Objection to Planning Application

158 Hawthorne Way, Shelley, Huddersfield, HD8 8PX

Application: Change of use of garage to treatment room for hairdressing, including installation of bi-fold doors (Agent ref: 383-26-R1)

Council application reference: 2026/62/91926/E

The below plan indicates the clients' ownership boundary:

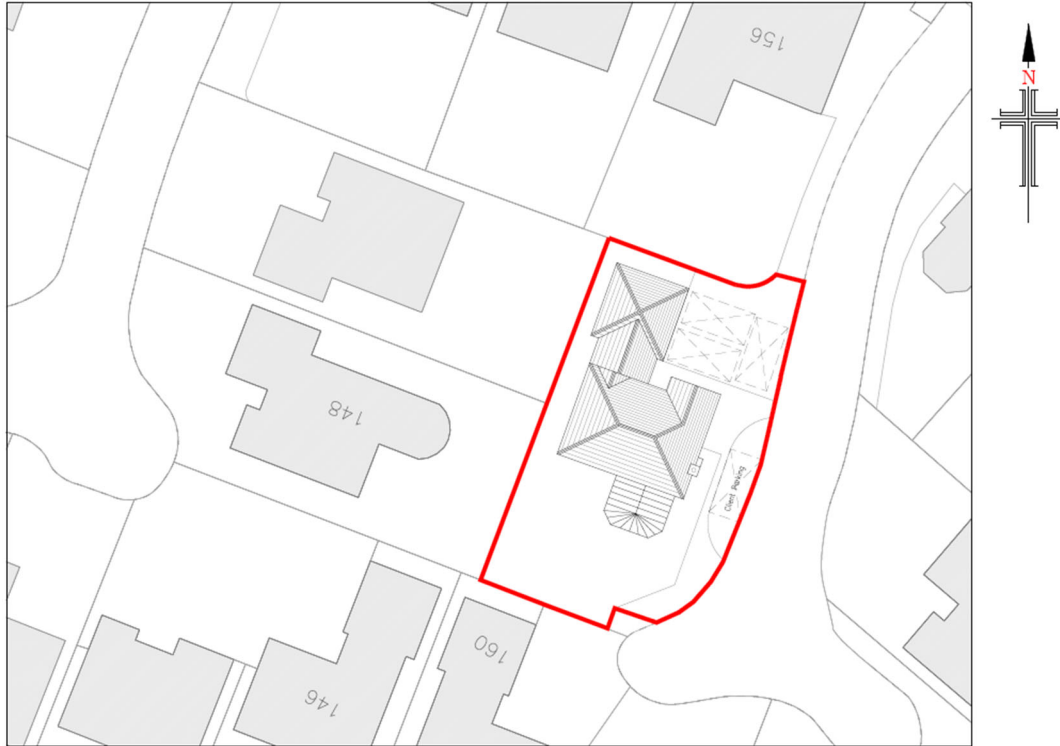
The application relies on a solicitor's letter asserting private ownership of the layby area. This claim is contradicted by the position on the ground and by the official records:

- The boundary of the properties, as shown on the official records where the dashed lines and in the case of 158 and the border of 160 it runs along the stone wall at the rear of the property and the fence line along the inside edge of the layby. The layby itself sits **outside** the ownership boundary.

- The layby forms part of the adopted highway and the 2m service strip. If it was adopted along with the estate roads, it is publicly maintained land and no private party can claim exclusive use of it or designate it as customer parking.

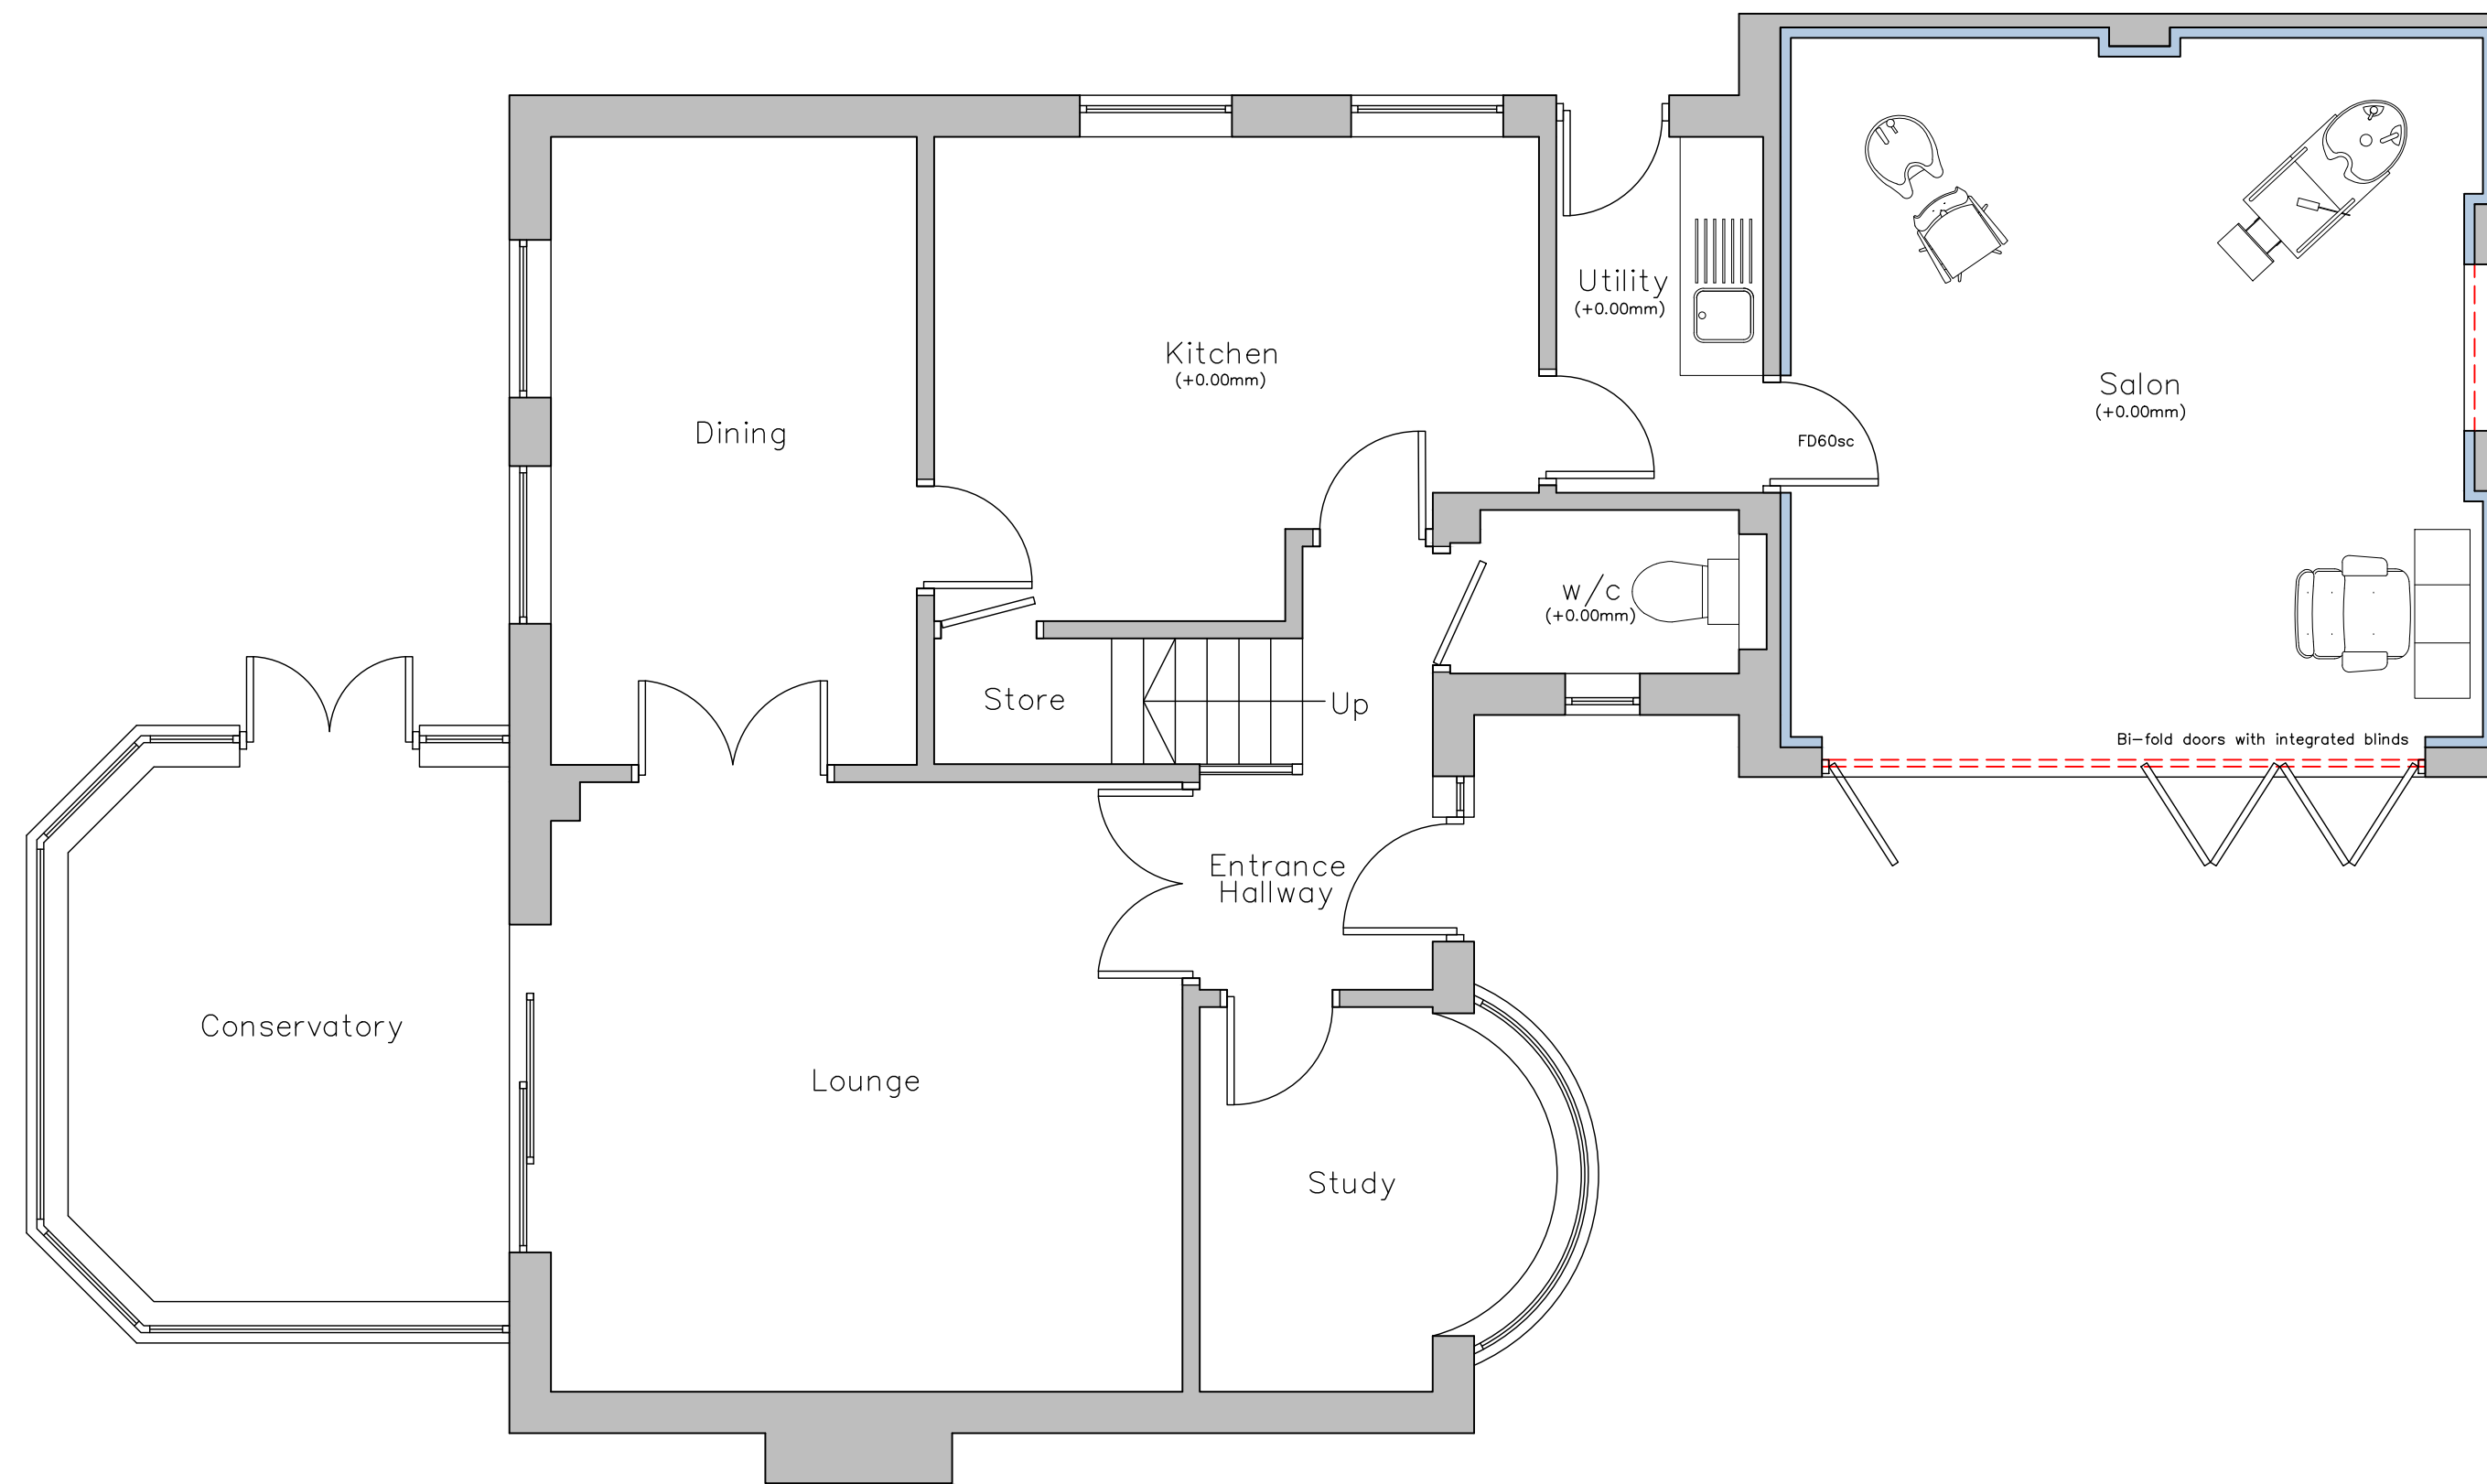
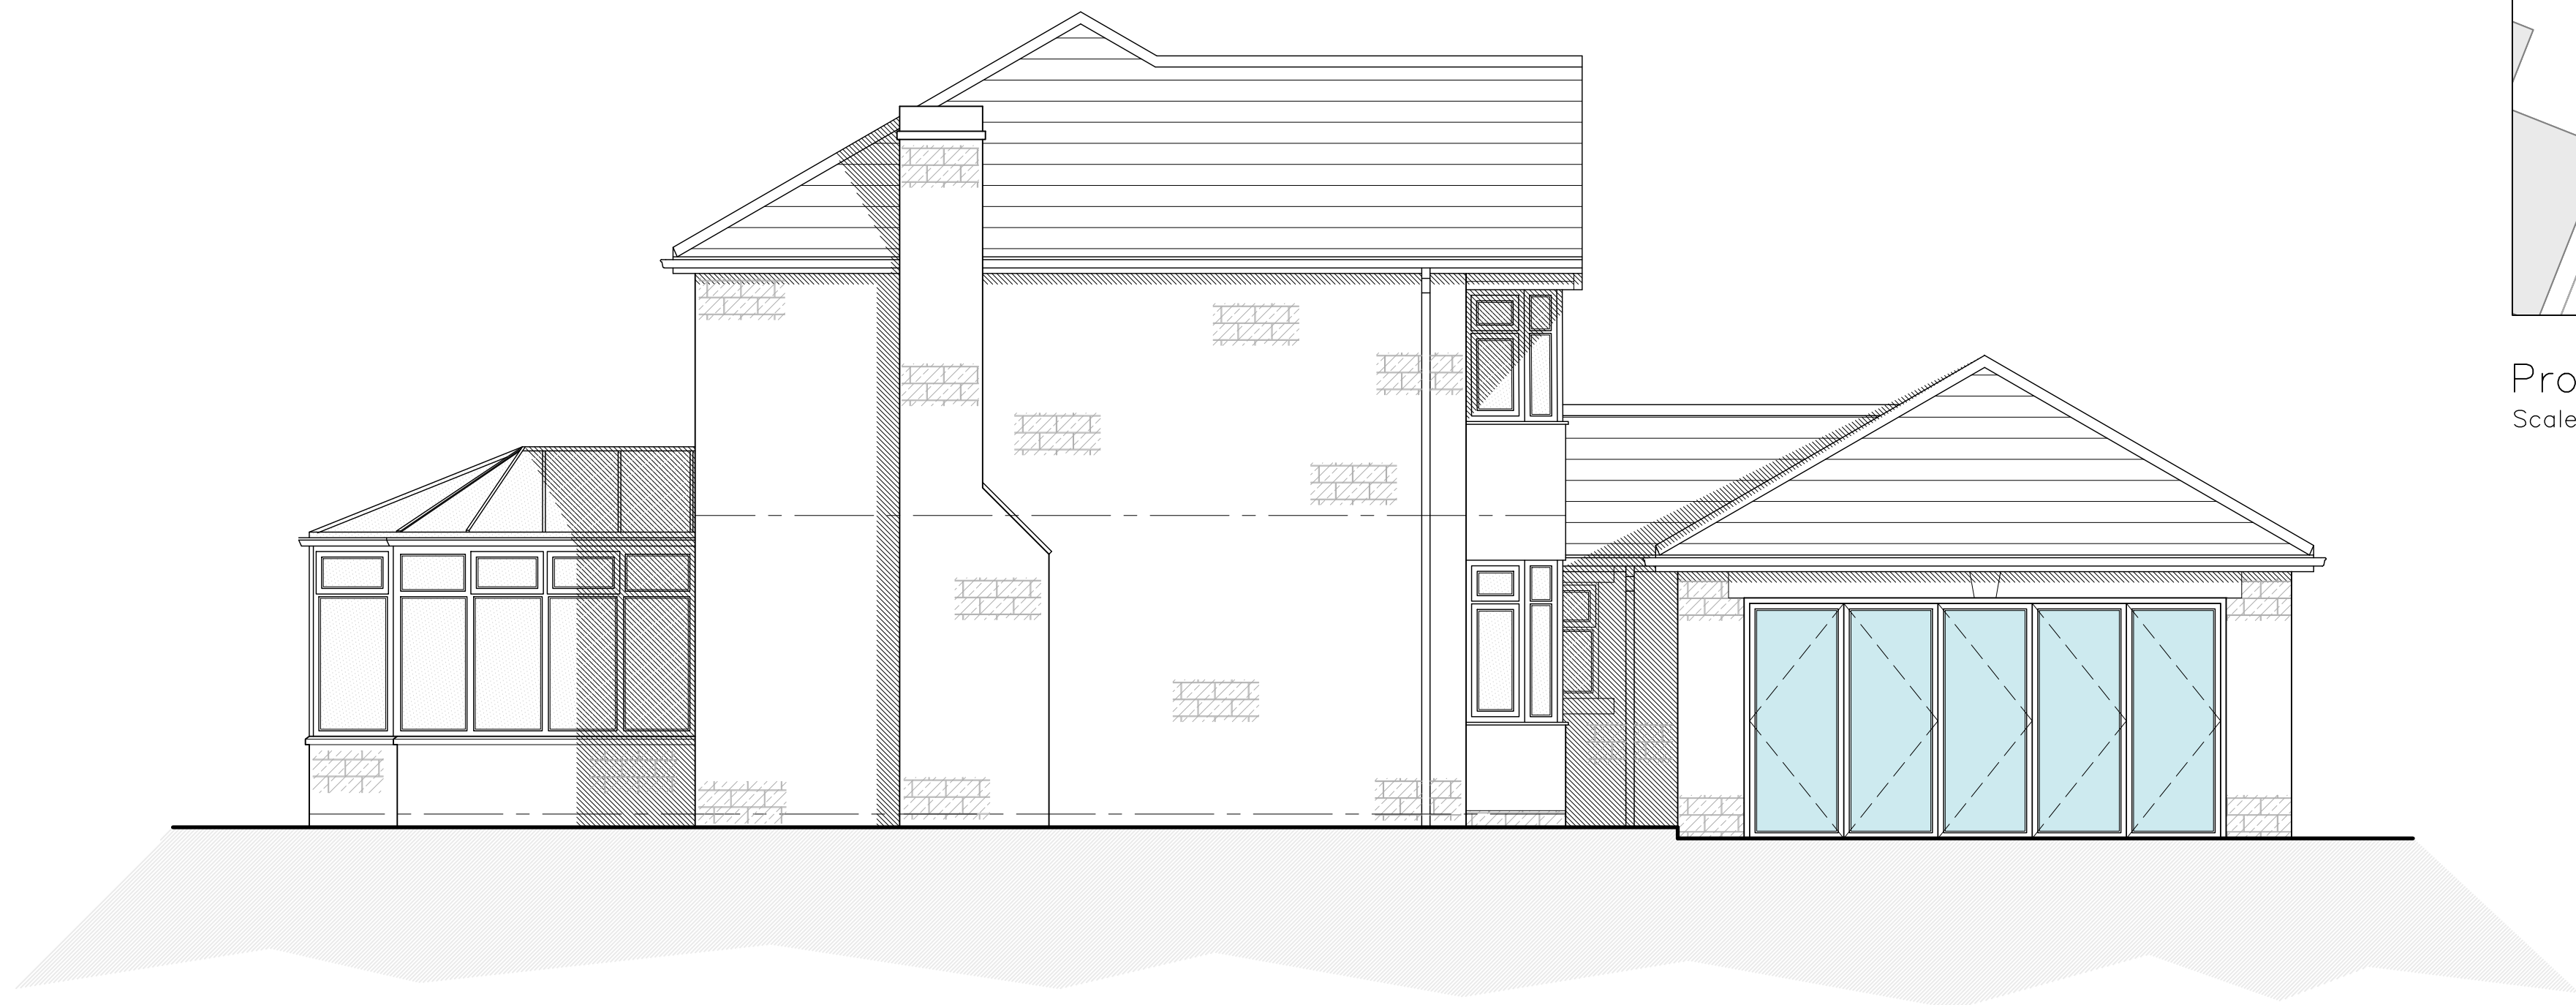
- I would further draw the Council's attention to the fact that the site plan submitted with the application is **misleading as to the extent of the driveway**. The concrete divider line that originally separated the driveway from the protected service strip was removed by a previous owner, who tarmacked the drive and service strip over as one continuous surface, contrary to the restrictions applying to the strip. The application drawings present this enlarged tarmacked area as though it were all legitimate driveway, when in fact part of it is the service strip which should never have been surfaced over. The plans therefore do not accurately reflect the lawful extent of the parking area, and the Council should not rely on them when assessing the parking provision.

- The submitted plans show three parking spaces on the drive, with two positioned up to the property boundary. This takes no account of the clearance needed to **open the proposed bi-fold doors**, which are likely to require in the order of a metre of space and if access to the business is through those doors, a clear gap would be required at all times. In practice there is not space for three cars on the drive: the third vehicle would have to sit partly across the bottom of the drive and partly on the road, obstructing the neighbour opposite when reversing into or out of their own drive.

- Full-height glazed bi-fold doors facing the street are a feature of **commercial premises, not domestic garages**. On a residential estate of traditional design, this alteration would read unmistakably as a **shop front**, visually announcing a commercial operation at the heart of a residential cul-de-sac.

- The application itself confirms this commercial character: the doors are to incorporate “integrated blinds to maintain privacy **during operational hours**” — language that describes retail premises, not a dwelling.

- The design is entirely out of keeping with the character and appearance of the street scene, where properties present traditional garage doors and domestic frontages. No other property on the estate has anything resembling a glazed commercial frontage.

- There is an established local precedent for how garage conversions should be handled on this estate: at **168 Hawthorne Way**, the garage door was replaced with brickwork and two windows, in keeping with the domestic character of the street. If any conversion were to be permitted here, that is the appropriate treatment — not a full-width glazed opening.
